**Consultation Response from KC,
Ecology Unit**
2024/92236 Wood Street Mills, Wakefield Road, Scissett, Huddersfield, HD8 9JS
Demolition of existing industrial building and erection of storage and distribution building with car park and associated engineering works
Date Responded: 30/09/2026
Responding Officer: Z. Hanshaw
Responding Ref: 2609/58

File Identifier	Project	Originator	Volume	Level	Type	Role	Number	Revision
PTWR - MWA - XX - XX - DR - A - 0005								P1

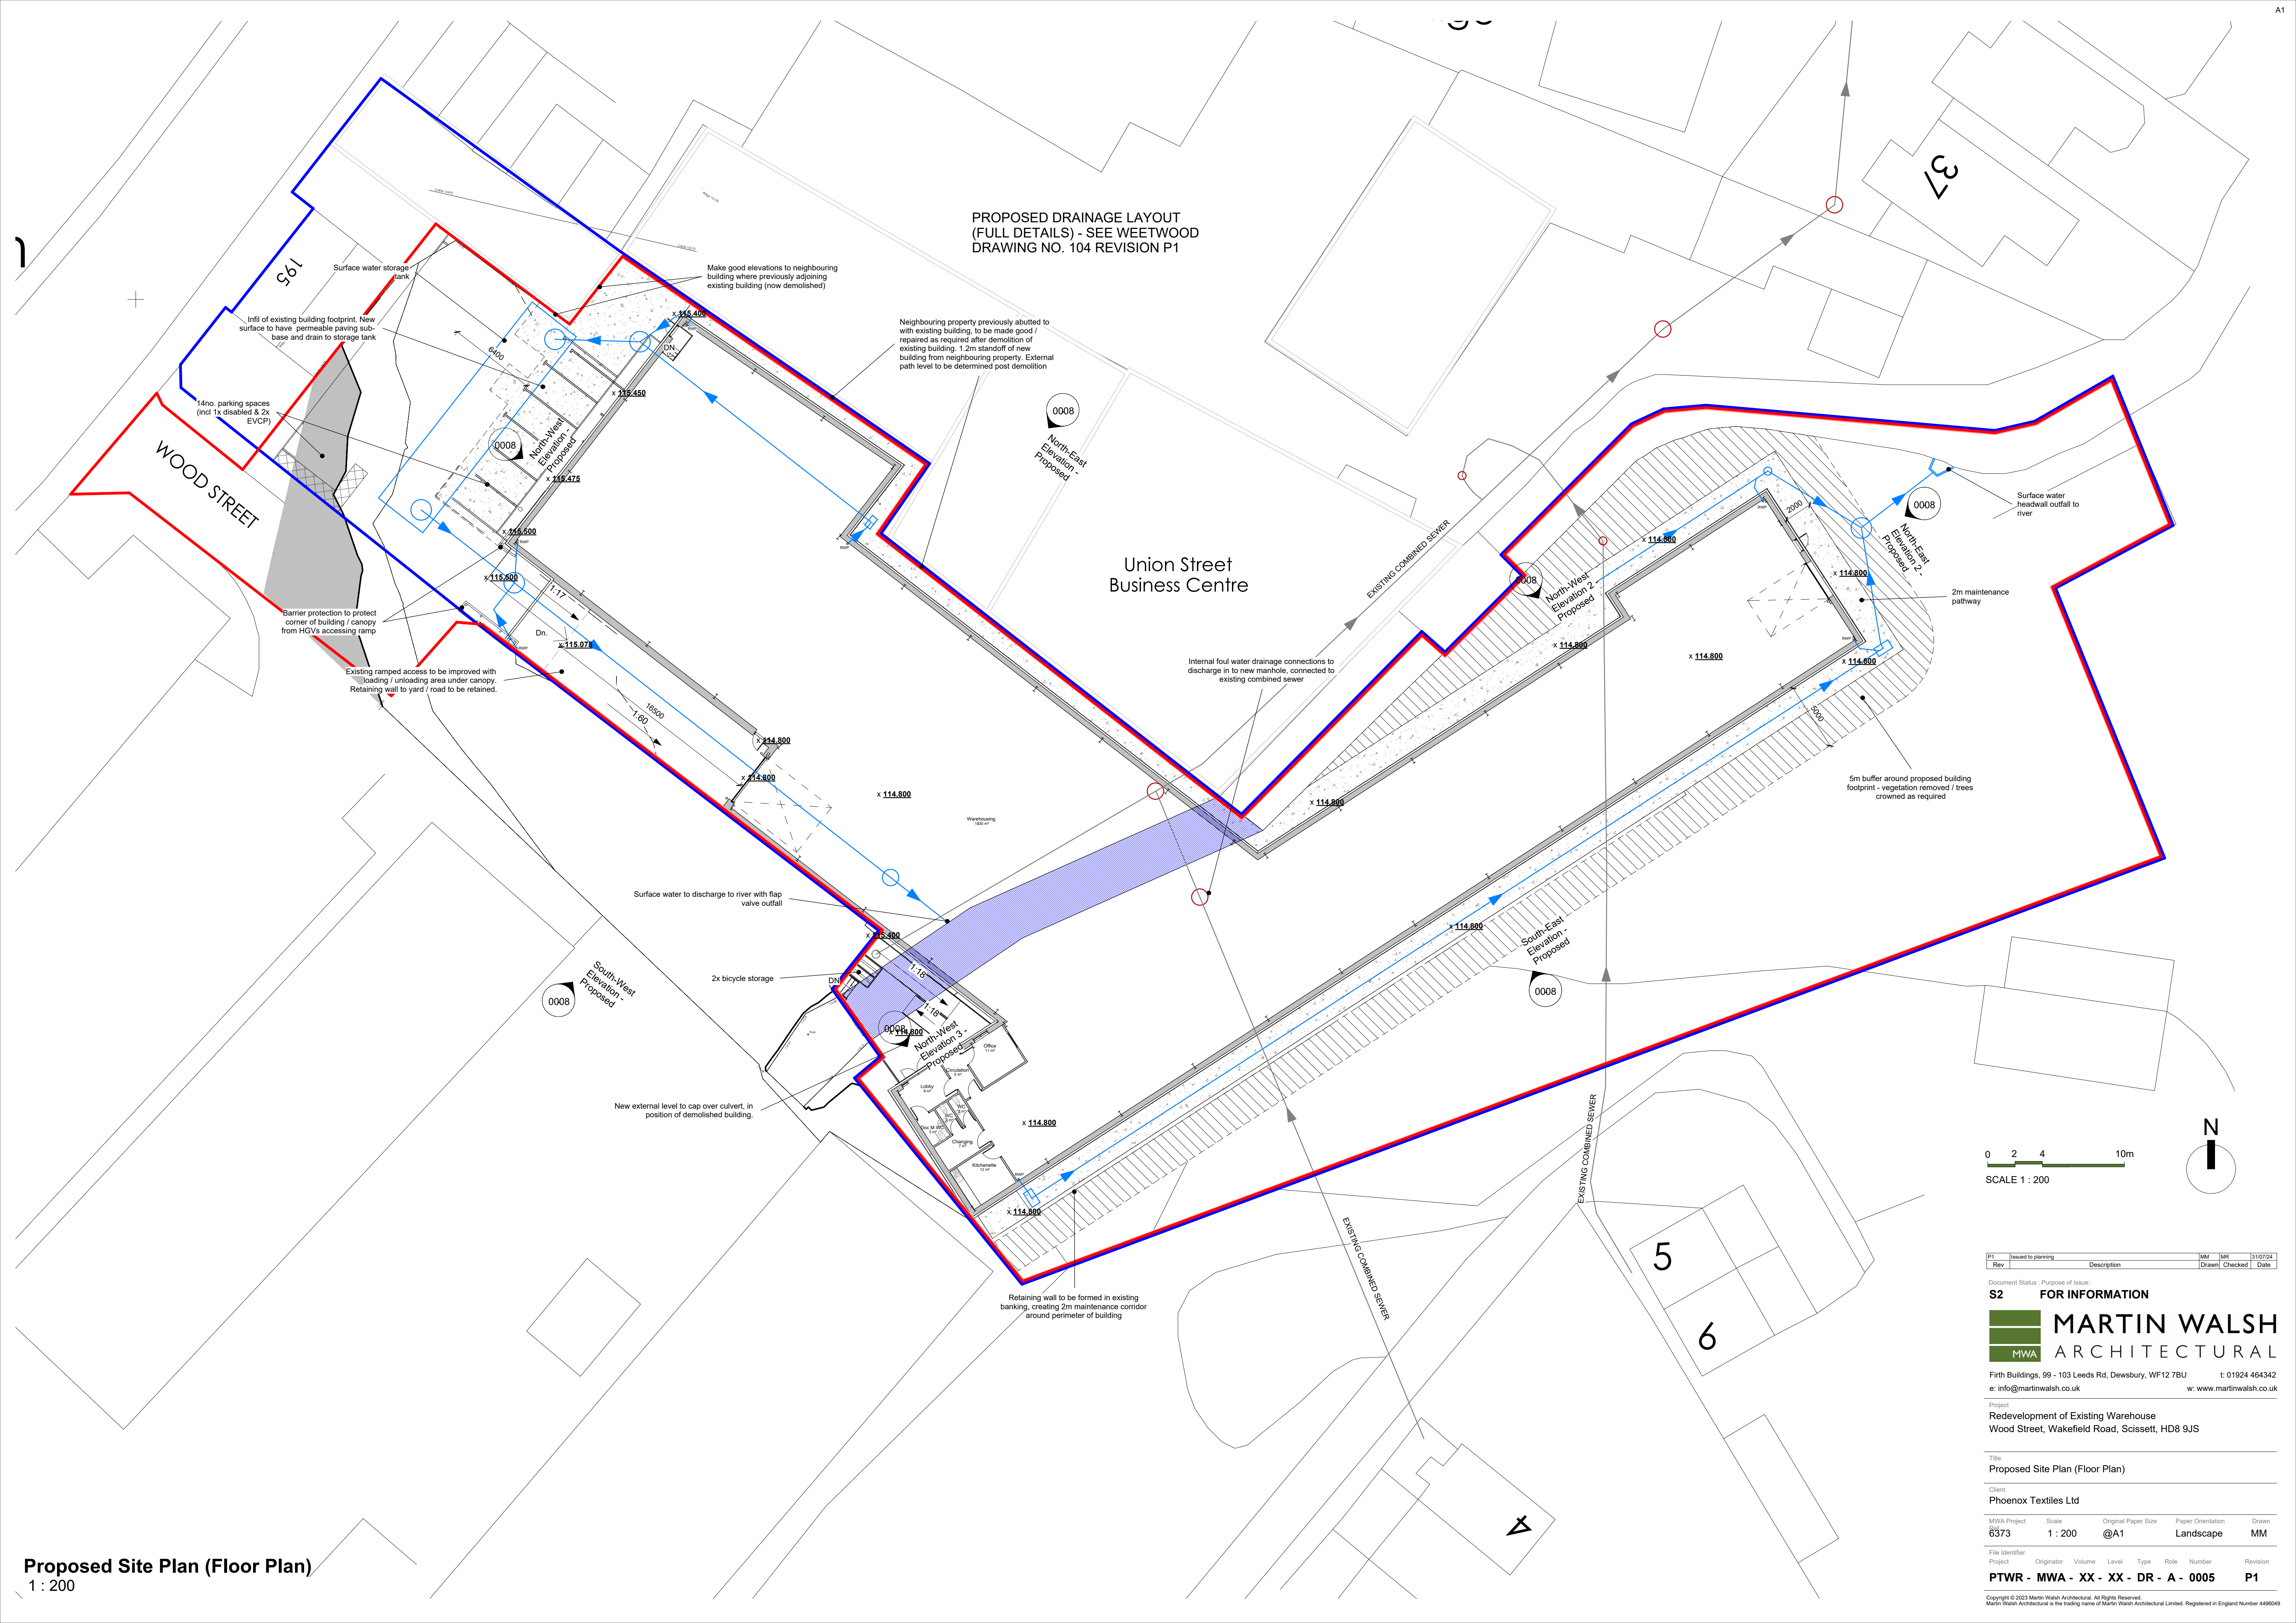
I would also request that further information on the delivery of Biodiversity Net Gain onsite is provided. The Metric and Report detail that there are 1.73 habitat units at baseline and 0.49 watercourse units at baseline. Post development there would be 1.29 habitat units, and 0.49 watercourse units. This equates to a net loss of 25.64% of habitat units and a net gain of 1.67% in watercourse units. This does not meet the 10% net gain requirement as set by the Environment Act. The Biodiversity Net Gain report states that offsite units will be required for this development. I would recommend that further details of this offsetting are provided. I strongly support the proposed de culverting and enhancement measures proposed within the watercourse, I note that the enhancements proposed are low impact, as any major works would need to be considered by a hydrological expert. It may be appropriate to consider this further, as the [the figures from February 2026 put the cost of offsite purchase of watercourse units](#) at £141,450 and the cost of woodland credits at upwards of £33,922. This report also details that watercourse units are scarce. The cost of these units may have an impact on the viability of the development and

therefore I would recommend that further consideration to the mechanism to achieve Biodiversity Net Gain is considered. The comments from the EA detail that the Applicant may own or manage more of the River Dearne than included within this redline boundary, and therefore there may be opportunities to deliver the net gain for watercourse and habitats within the applicant's ownership, which may reduce the costs of Biodiversity Net Gain delivery.
